# KITTITAS COUNTY FIRE MARSHAL'S OFFICE

Re: Knowles (BL-12-00015)

After conducting a review of the above named project, I have the following comments:

**Survey for  
Boundary Line Adjustment**

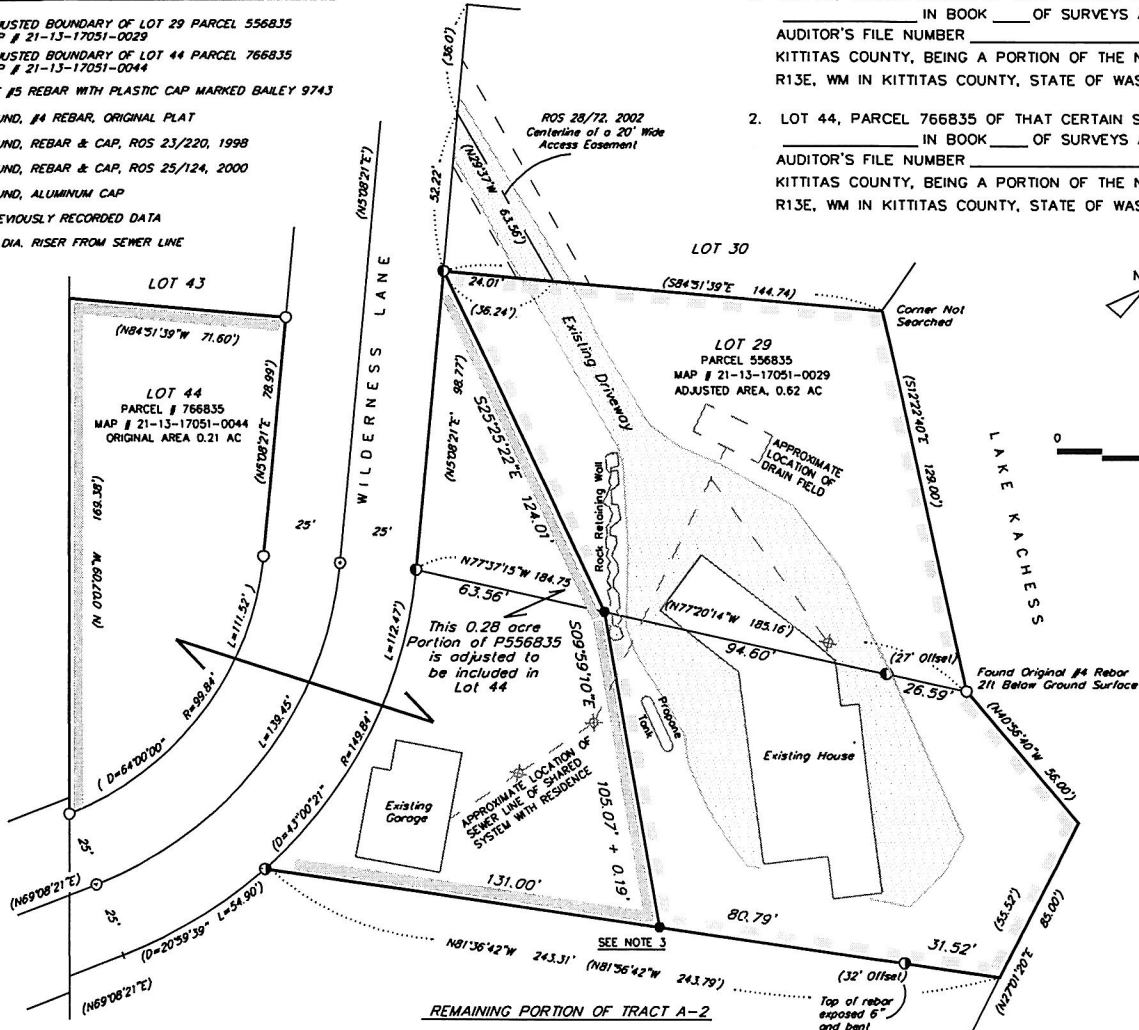
- Ensure that boundary line adjustments do not infringe upon existing structures, to include propane tanks, etc.
- All future development must comply with the International Fire Code.
